DECISION DELEGATED TO HEAD OF PLANNING

Application No: H02-0866-25 **Applicant:** Mrs K Hutson
Proposal: Erection of Detached Single Storey Dwelling
Location: Land Rear Of 75 South Street Crowland
Terminal Date: 30th January 2026

proposed elevations - 1:100 scale

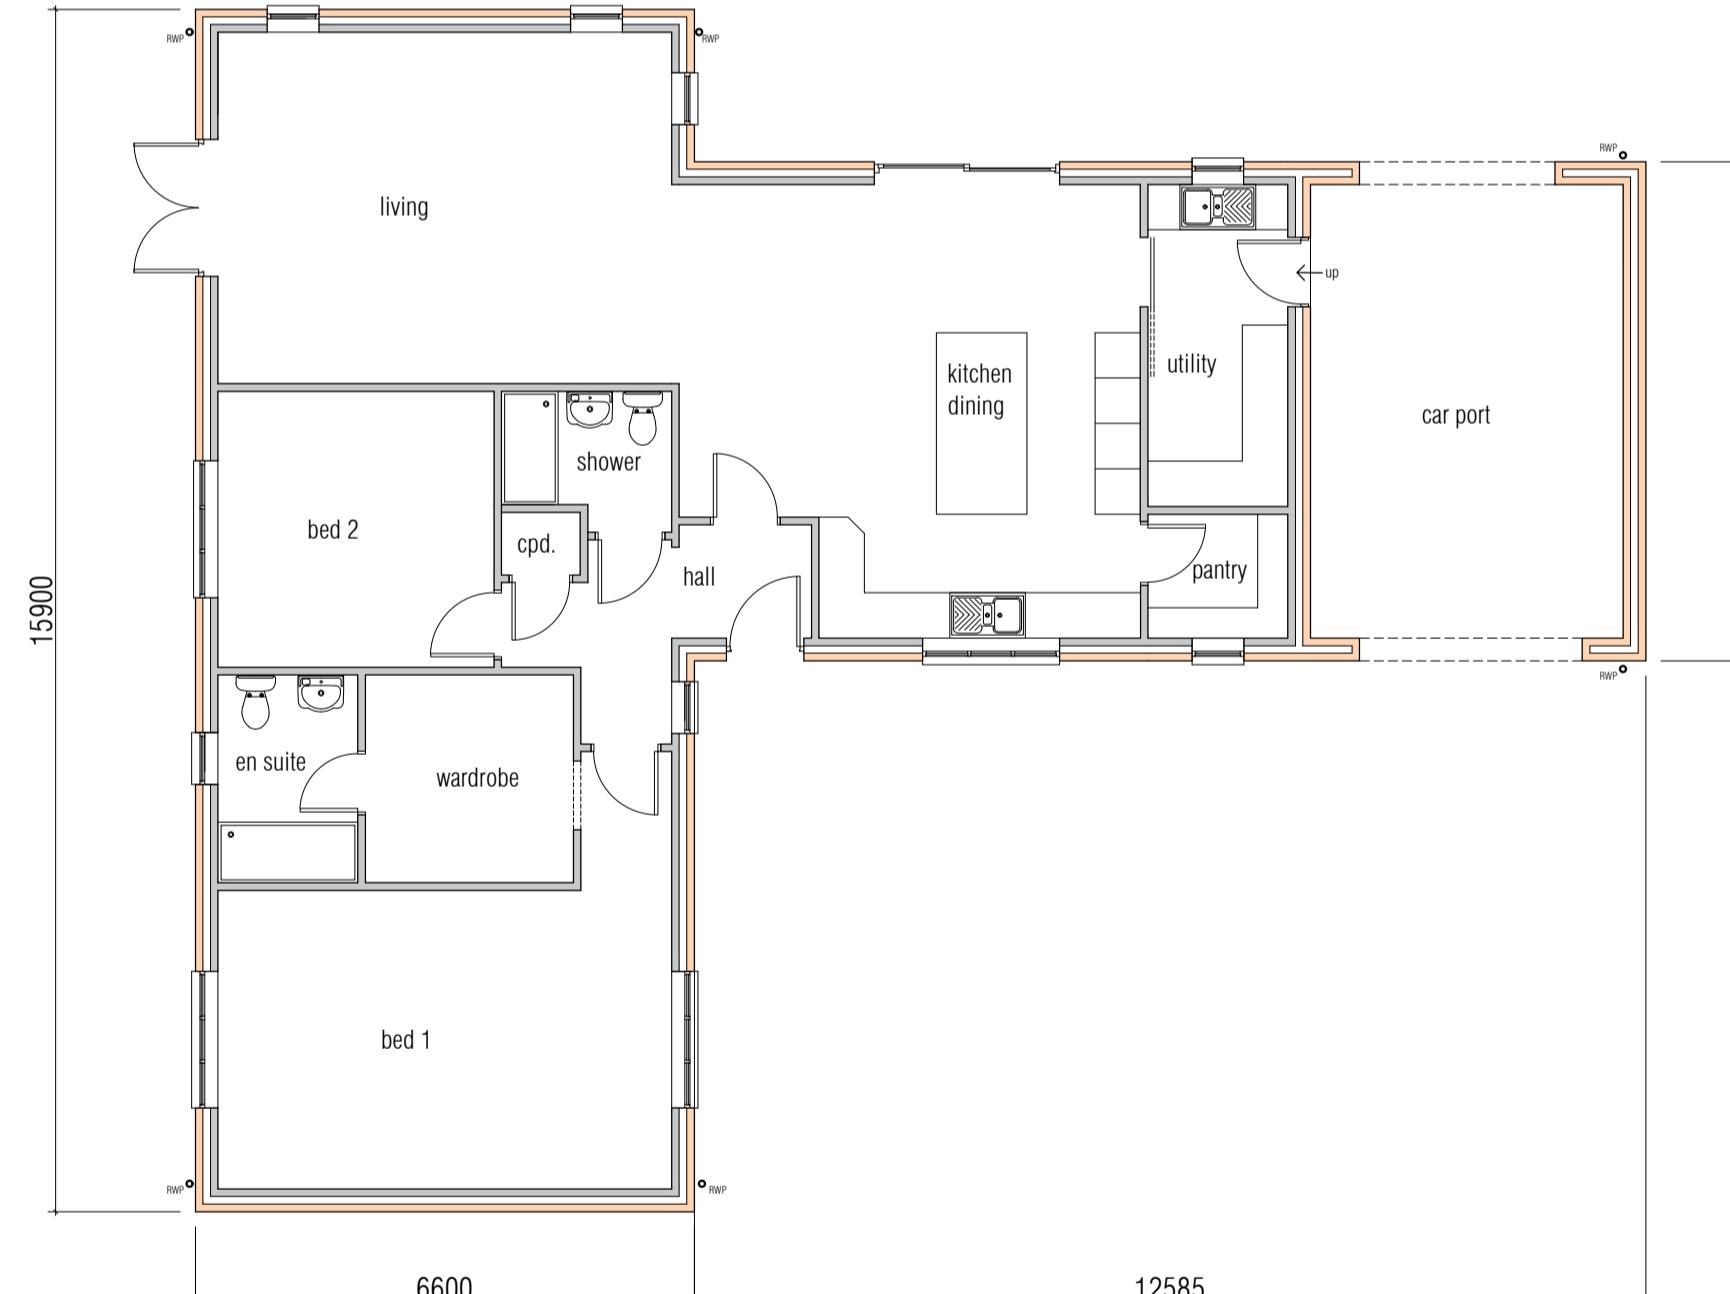
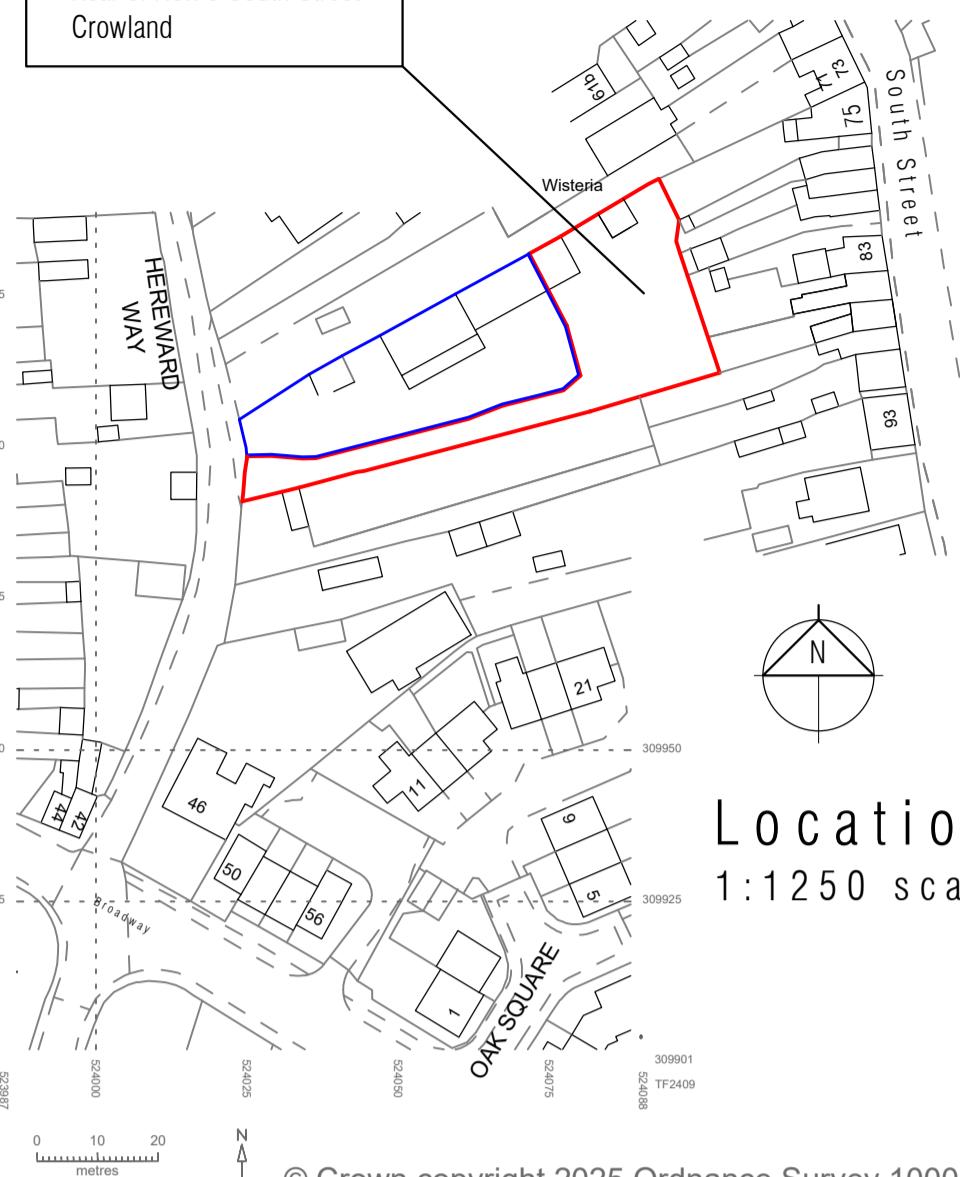
The dwelling itself is single storey with hipped roof structure above and includes undercroft parking. The proposed plans show that the finished materials will be a multi-red facing brick, smooth grey roof tile, cream finish PVC-U casement openings, composite door in anthracite and black rainwater goods. The floor plans show that the dwelling is a two-bedroom property.

The proposed materials are annotated on plan, and within the planning statement the applicant considers that the use of timber frames would be unreasonable. Under the previous submission the conservation officer made comment stating *"full details of external materials, as well as details of windows and doors to be submitted. I would also suggest applying a condition requiring all rainwater goods to be black-painted metal. The applicant should also be informed that upon submission of the details requested by these conditions, it shall be an expectation that doors and windows shall be timber framed, and that roof coverings are natural materials (either slates or clay pantiles)"*

In this case the rainwater goods are upvc, and the roof materials also differ. Therefore, whilst the form maybe appropriate (given it is balanced against the existing permission) the materials will need controlling as the palate is not wholly appropriate. Therefore, a condition controlling materials will be attached.
